Office of
Environment
& Heritage

Our Ref: DOC17/633491
Your Ref: SSD 8169

Re: Environmental Impact Statement - State Significant Development 8169 and Modification 3 of the Major Project 09_0028 (Concept Plan) for the North Byron Parklands Cultural Events Site, Yelgun.

Attachment 1: Detailed OEH Comments – SSD 8169 and MP 09_0028 Mod 3 for the North Byron Parkland Festival Site, Yelgun

FAUNA GATES

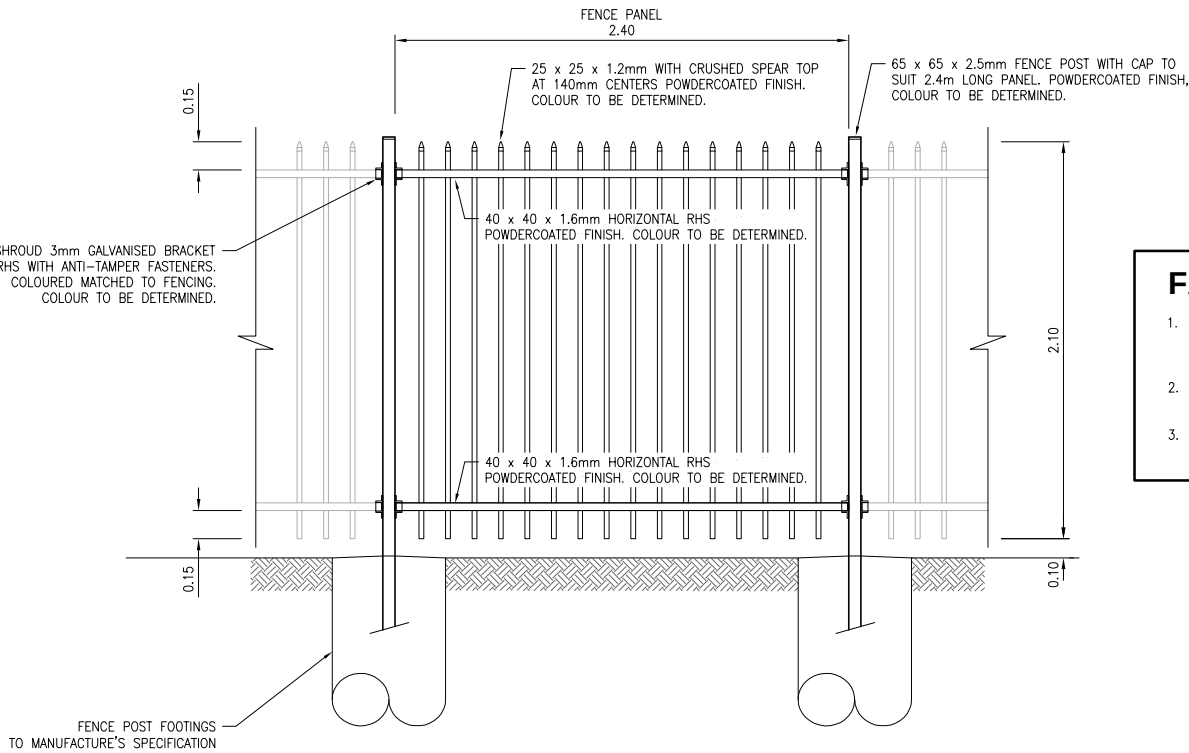
- Two different specifications are given for the proposed "Fauna friendly fencing". The temporary koala fencing has a 250mm gap above ground level and the permanent security fencing has other a 100mm gap. The reasoning behind either design is not provided. NPWS would like this clarified i.e. which height is designed to allow which fauna access and egress. In the absence of other data, NPWS favours a 250mm gap for both fences to allow larger fauna through e.g. echidna and northern brown bandicoot.
